Date: 22nd October 2021
Your Ref: A/26/21/RES
Our Ref: 12491D

TOWN AND COUNTRY PLANNING (DEVELOPMENT MANAGEMENT PROCEDURE) (ENGLAND) ORDER 2015: APPLICATION FOR THE APPROVAL OF RESERVED MATTERS IN RESPECT OF OUTLINE PERMISSION ALLOWED AT APPEAL (APP/C3810/W/17/3185128) AT LAND SOUTH WEST OF BROOK LANE AND SOUTH OF A259, RUSTINGTON

We act on behalf of Store Property Investments Ltd (the Applicant) and write to share additional information for application A/26/21/RES for:

SPARUST(BROOKLN).1/02

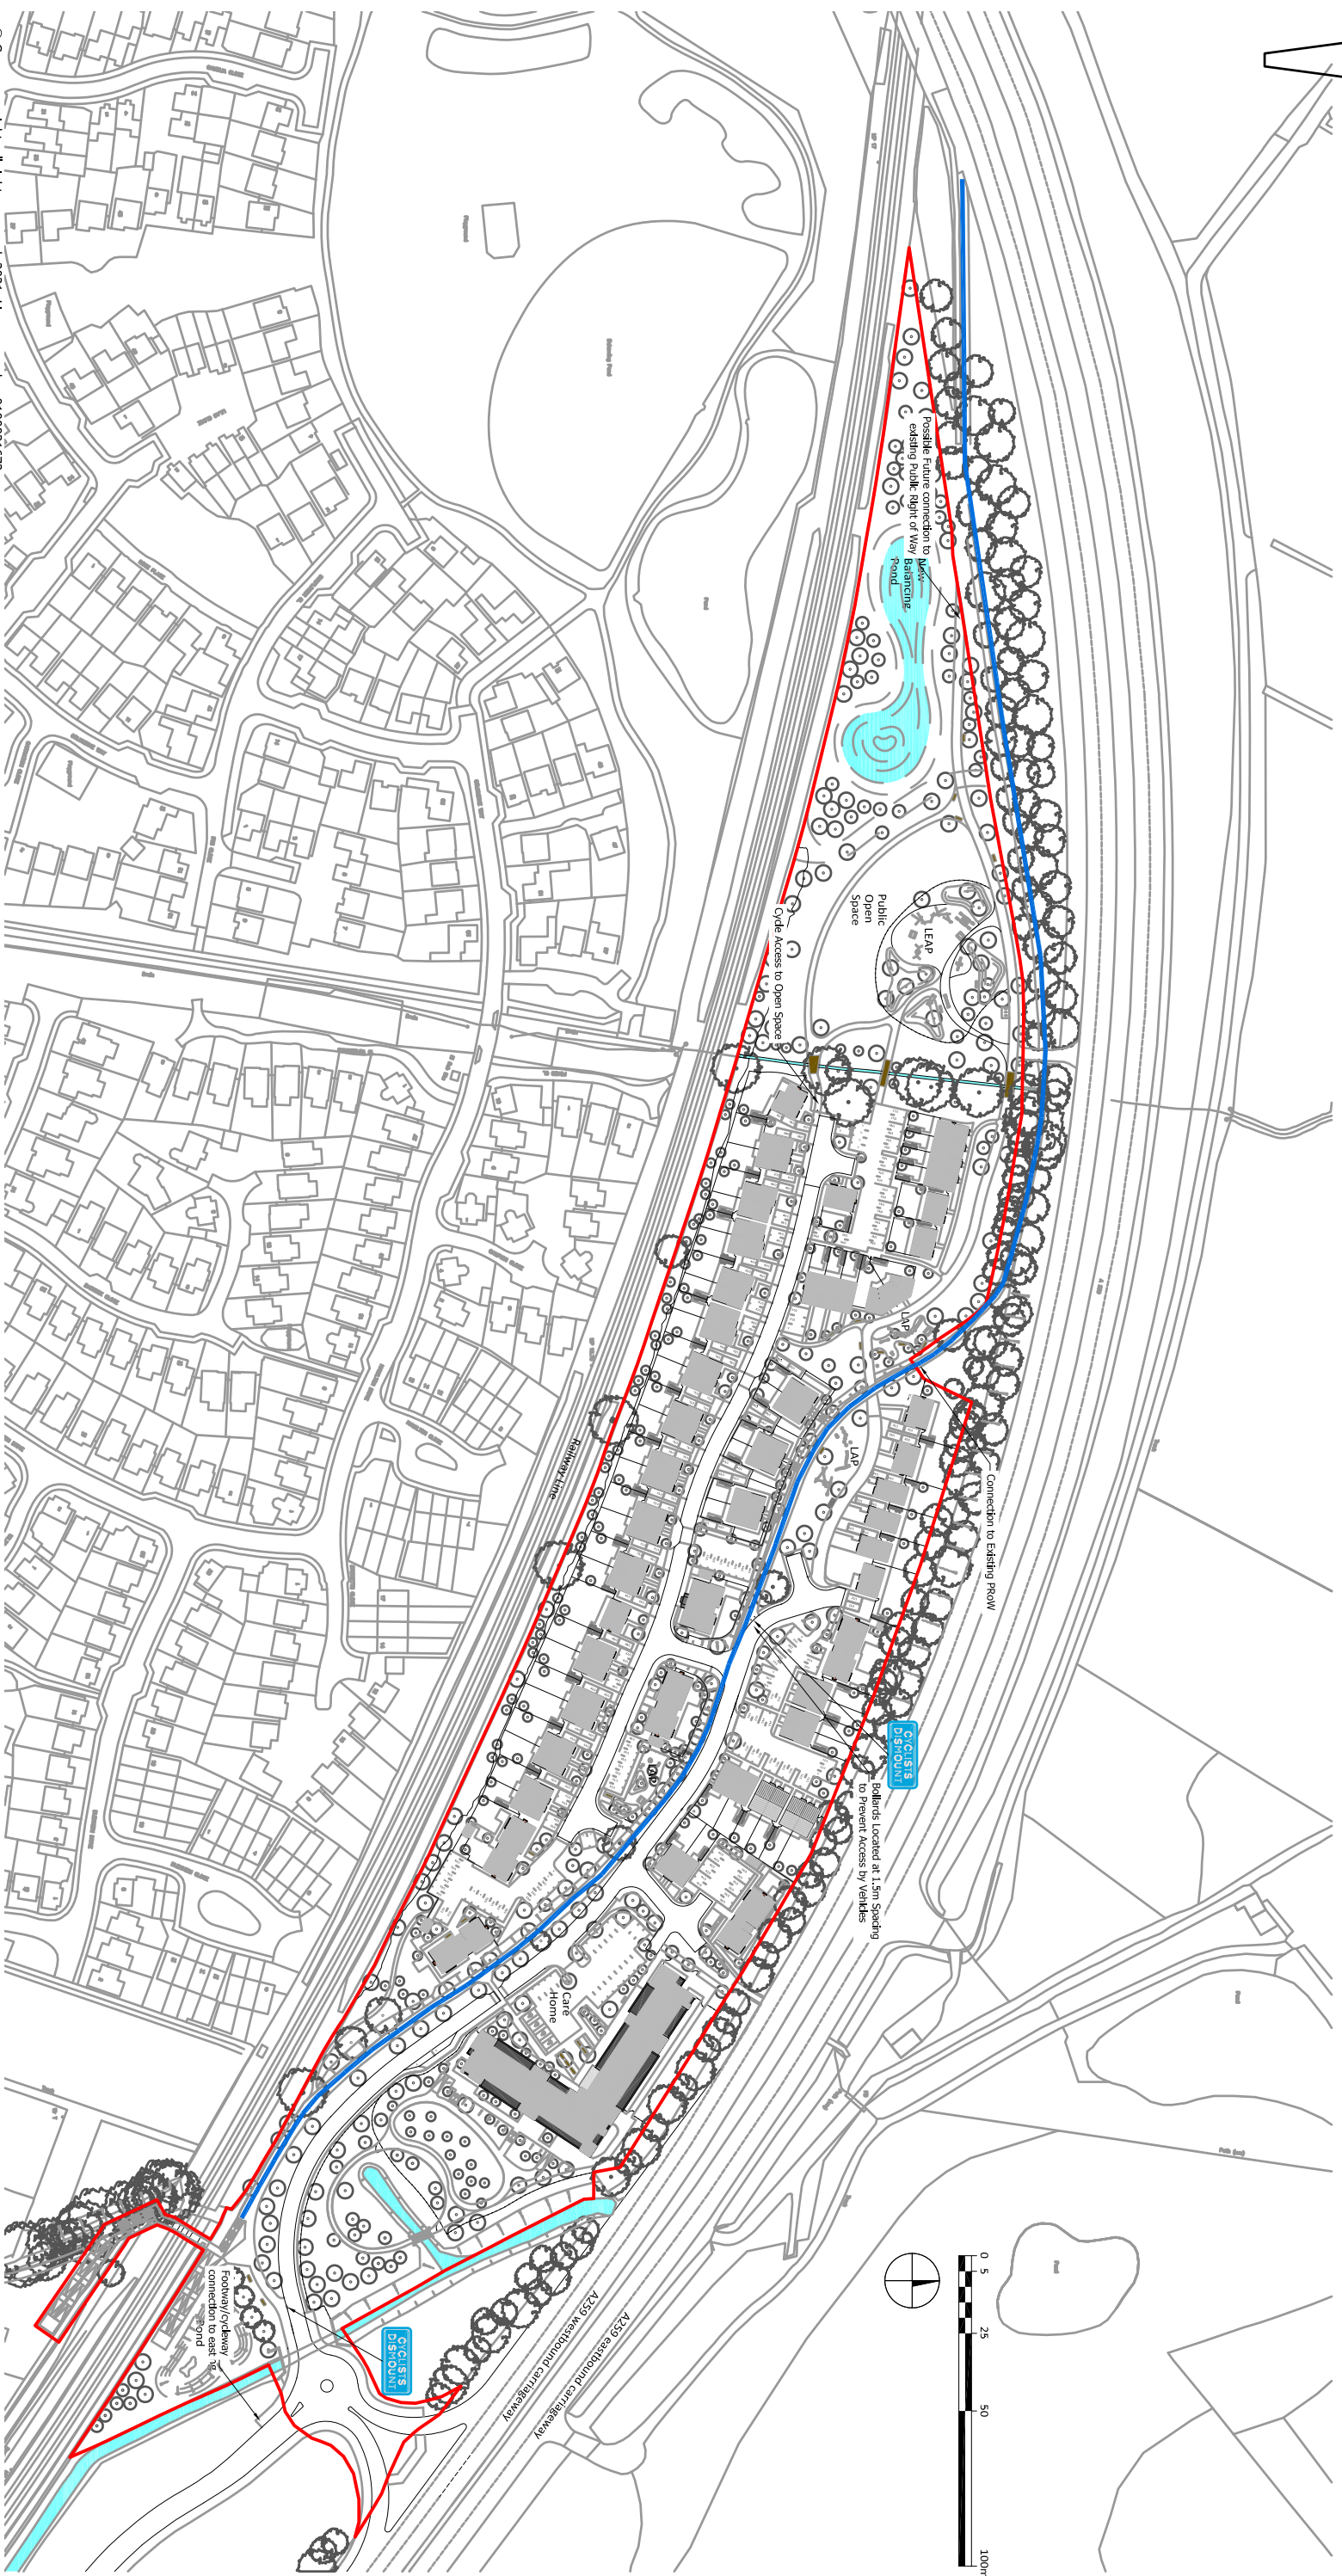
"In response, whilst cyclists are allowed on the section of Public Right of Way FP2159 that is being urbanised into a road, from the point where the developer proposes to install bollards to prevent vehicular use,

1) We would need to approve these bollards, we would need to see a demonstrable need for their installation and approve the design,

2) Cyclists are not allowed to proceed along the footpath without permissive cycle rights being given under agreement by the landowner.

I note also that to the west of the development, the developer has indicated that their internal cycle path will join with FP2159 outside their red line boundary.

Again, any cyclists that have cycled through the green area along the developer's cycle route will have to dismount once more without the same permissive cycle rights being given by the landowner. Does the developer have control over the land at this point to give permission? We obviously can't enter into any permissive agreement on land outside of their control.

We appreciate the developer's desire to promote sustainable and active travel modes however, with no ability to continue cycling along FP2159 in either direction outside the developer's red line boundary, there is no sense in allowing cyclists to use FP2159 so little incentive to enter to any permissive agreement along any of it. The section from the bollards to the western point is under 500m and under the acceptable distance people are generally happy to walk."

"In addition to Donnas comments (any would highlight the issue of the red line boundary) I would draw attention to the applicants statement of case from the appeal. This details the onwards links and connectivity to be provided through the site which is not apparent within the RM application.

In addition to the bollards shown at the proposed site some would also be likely to be required at the area highlighted yellow on the plan below."
